# KITTITAS COUNTY

### MEMORANDUM

**TO:** Lindsey Ozbolt, CDS  
**FROM:** Christina Wollman, Planner II *CW*  
**DATE:** October 22, 2013  
**SUBJECT:** Valley Veterinary Hospital CU-13-00006

Driveway Design Template SU-30 and Smaller
Exhibit 1340-1

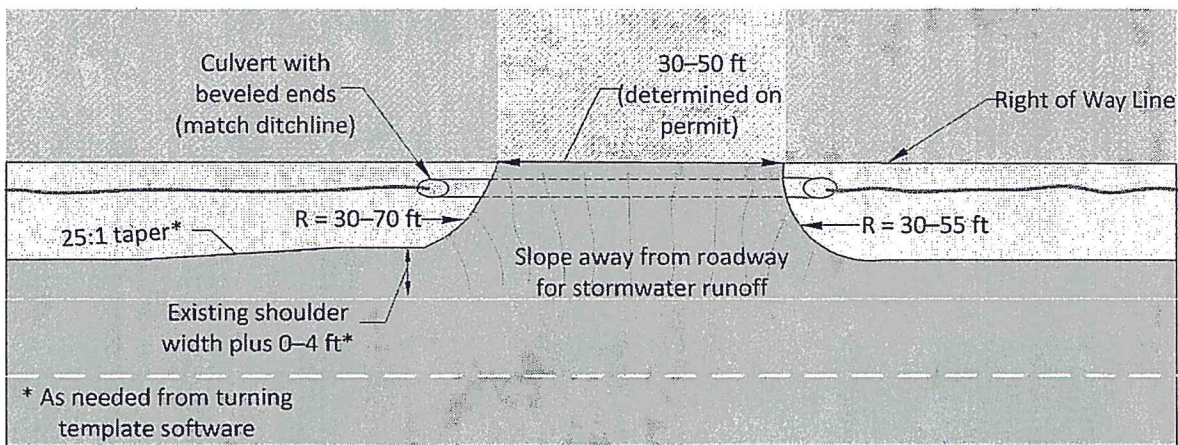
1. The approach into the property shall be constructed and designed to standards within the WSDOT Design Manual, current edition, Chapter 1340 and Exhibit 1340-1. The design shall be approved by the county engineer.

1 SITE PLAN
 SCALE: 1" = 20.0'

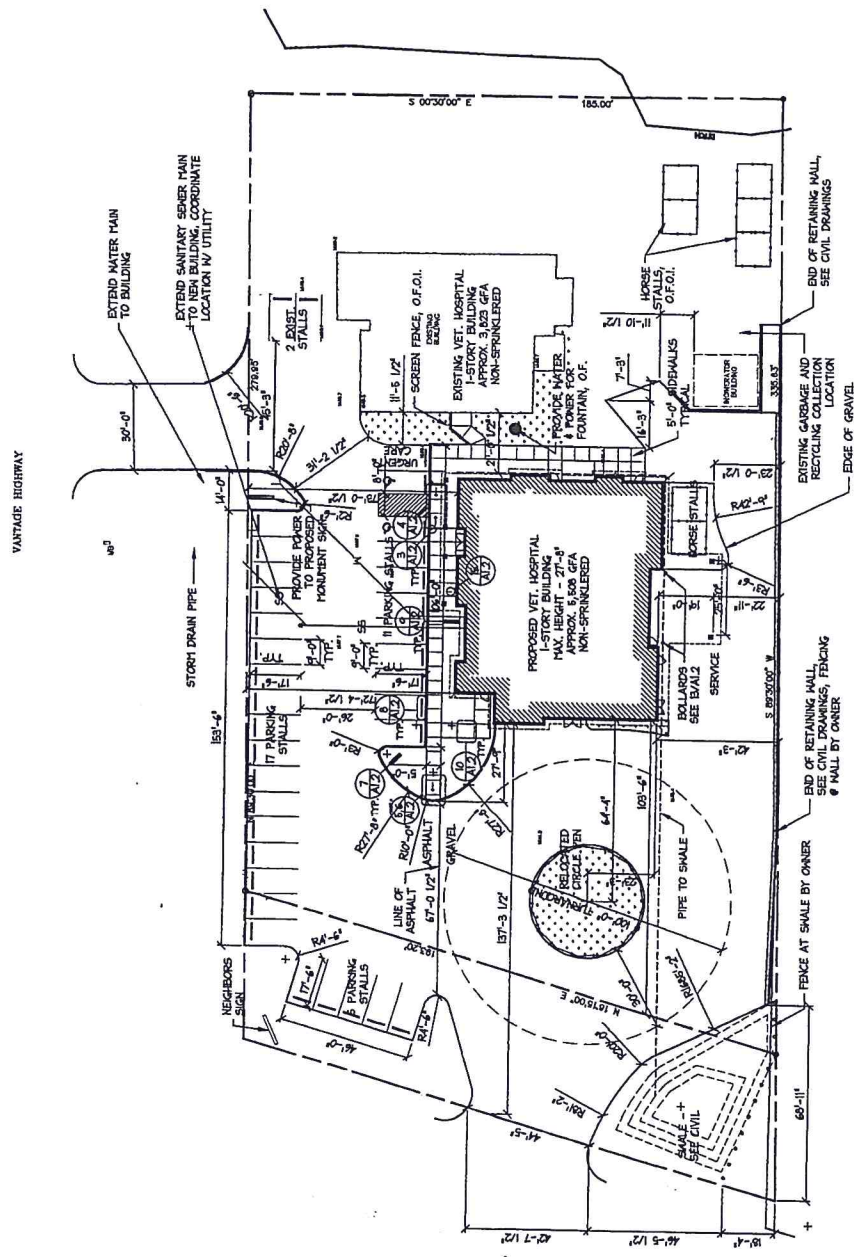
Kittitas County Public Works has reviewed the application for the expansion of the existing veterinary hospital. Public Works has worked with the applicant to perfect the site plan and access into the veterinary hospital. The applicant received a road variance to allow a second access into the site, using the neighboring business park existing approach (RV-13-15, attached).
